Case Officer: Lewis Knox

Applicant: Martin & Oonagh Garnham

Proposal: Single storey rear extension to replace existing Conservatory. Internal renovation works including a new Bathroom and stair to the second floor

Drawing Title:
Proposed Plans

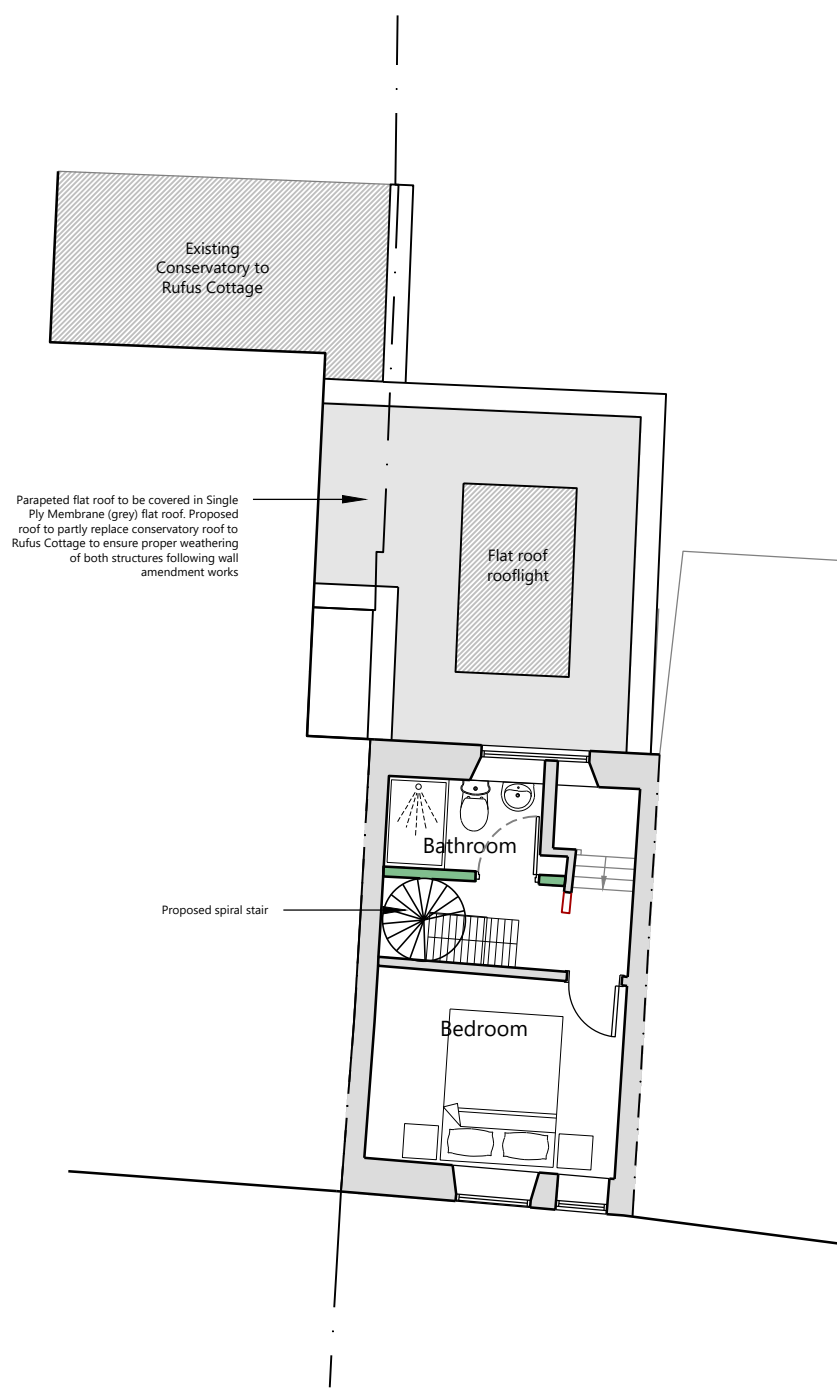
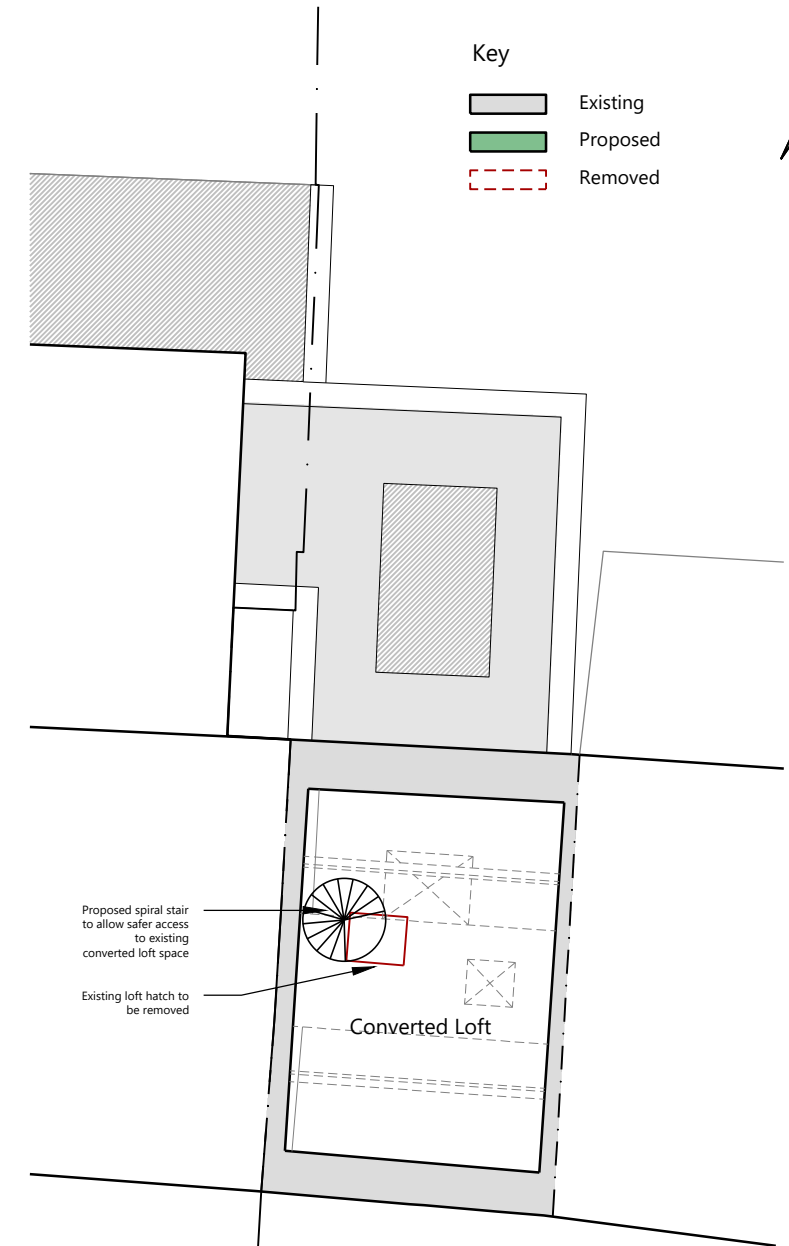
- 8.7. The replacement of the stairs from first to second floor will not result in a loss of historic fabric as the existing ladder stair is modern and there is already an opening. The details of the replacement stair should be provided to ensure that they are harmonious and in keeping with the internal character of the listed property. The submission of these details will be conditioned and should be received by the LPA prior to commencement of the works to the stairs.

4. Prior to the commencement of the internal works, full details of the proposed stairs from first to second floor levels and a method statement of installation, shall be submitted to and approved in writing by the Local Planning Authority. Thereafter the stairs shall be installed within the building in accordance with the approved details.

Drawing Title:
Proposed Elevations

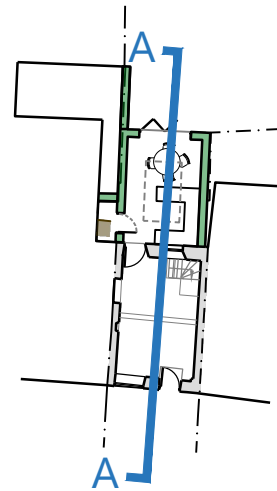
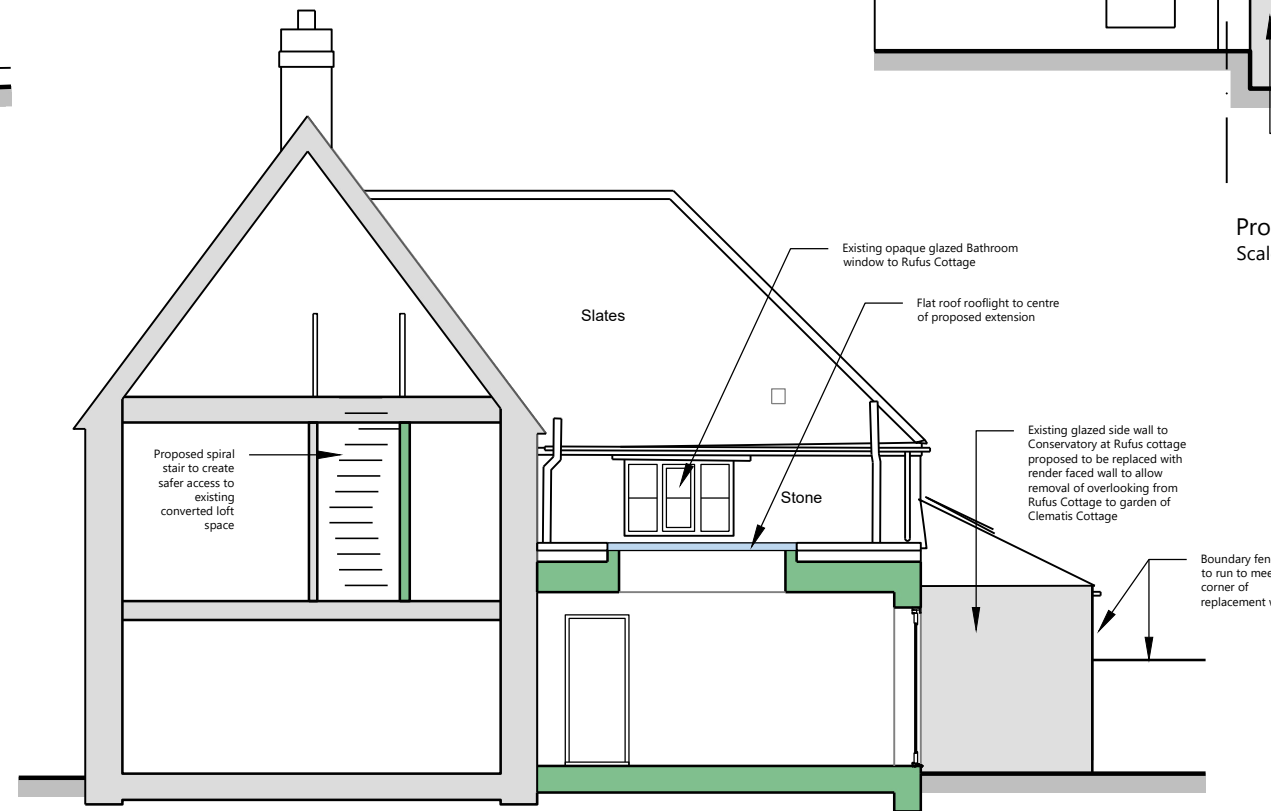
- 8.5. The extension to the rear is a large addition, however because of the existing situation with the dilapidated conservatory it is, on balance; considered not to result in a detrimental impact to the character of the building. It is considered that the appearance of the rear of the heritage asset would be somewhat improved through the proposals.

- 8.6. The use of stone to match the existing is welcomed as it is felt this will ensure a complementary development. The main external wall of the cottage should ideally not be plastered or treated.

3. The natural stone to be used on the walls of the rear elevation of the extension shall be of the same type, texture, colour and appearance as the stone on the existing building and shall be laid dressed, coursed and pointed to match that of the existing building.
